STATE OF NORTH CAROLINA
DEPARTMENT OF TRANSPORTATION

August 11, 2009

Subject: **Revised Permit Drawings and Calculations** for Improvements to SR 1733 (Weaver Dairy Road), from NC 86 (Martin Luther King, Jr. Boulevard) to SR 1734 (Erwin Road) Chapel Hill, Orange County, Division 7, Federal Aid No. STP-1733(11); State Project 8.2501601, TIP No. U-3306.

Reference: NCDOT Section 404 and Section 401 Individual permit application (March 25, 2009)

Site 3 Enlargement Site 3

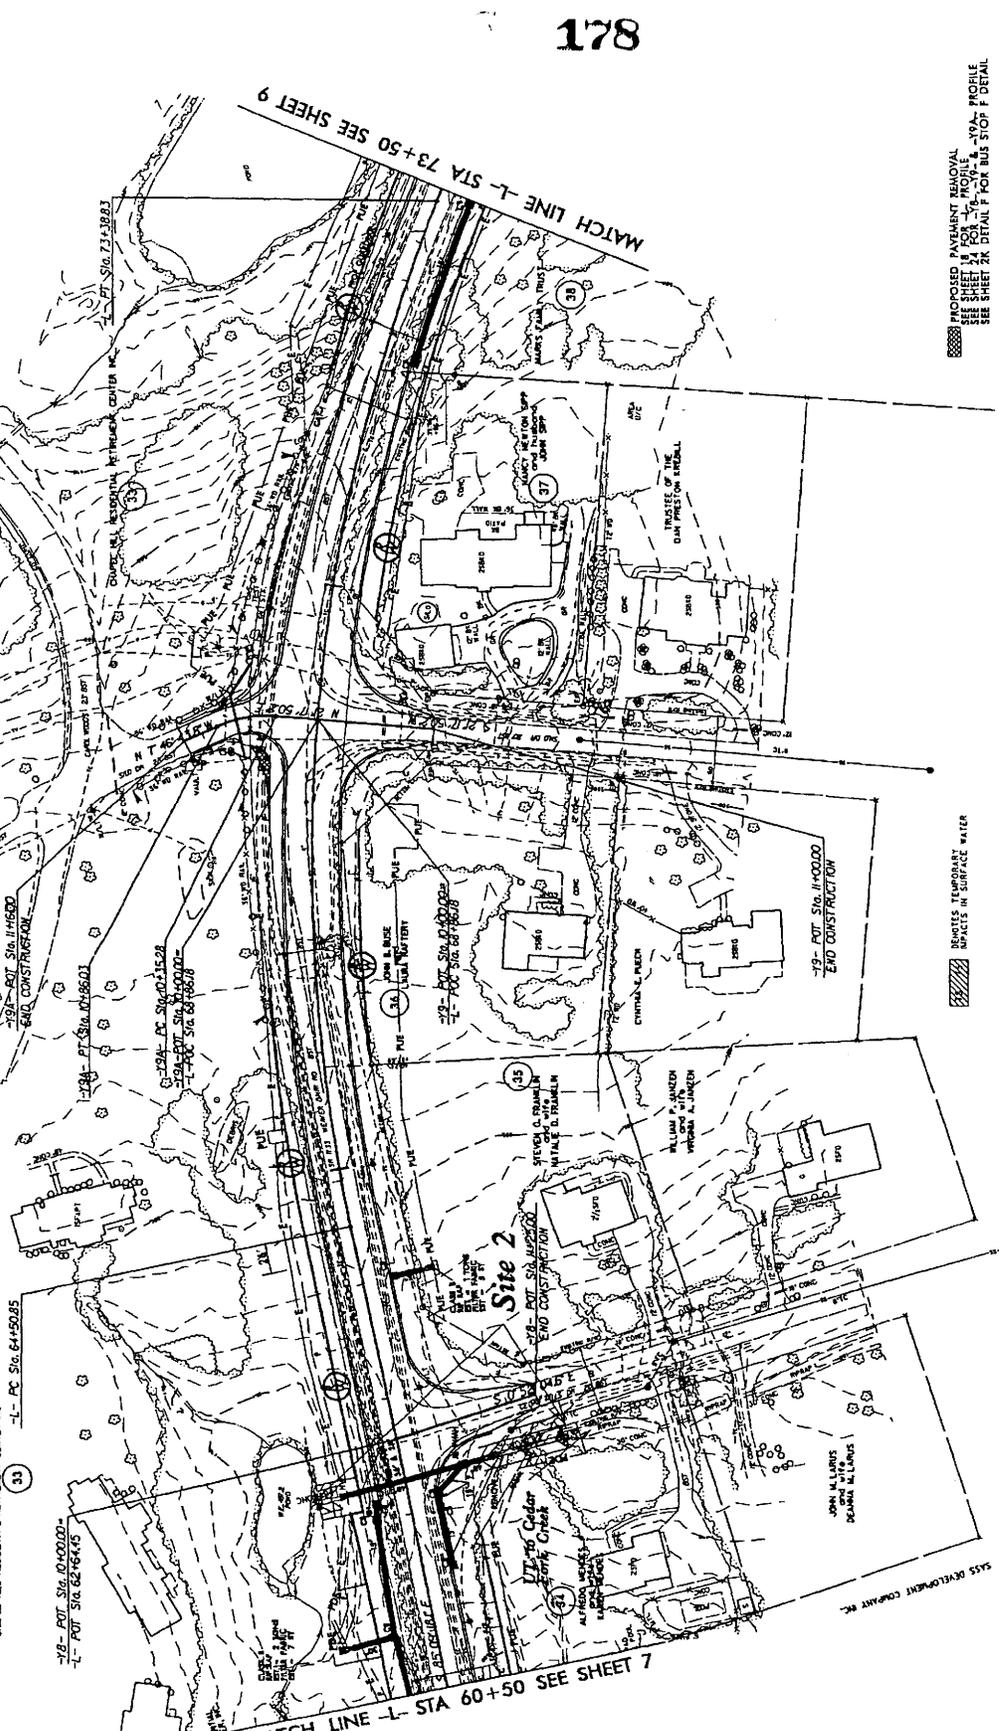
Enclosed are the calculations and the revised permit drawing sheets you requested. The hydraulic calculations show that rip rap was needed on the stream banks at Site 3 and revised drawings for Site 3 showing rip rap along the sides of the stream and not in the stream channel.
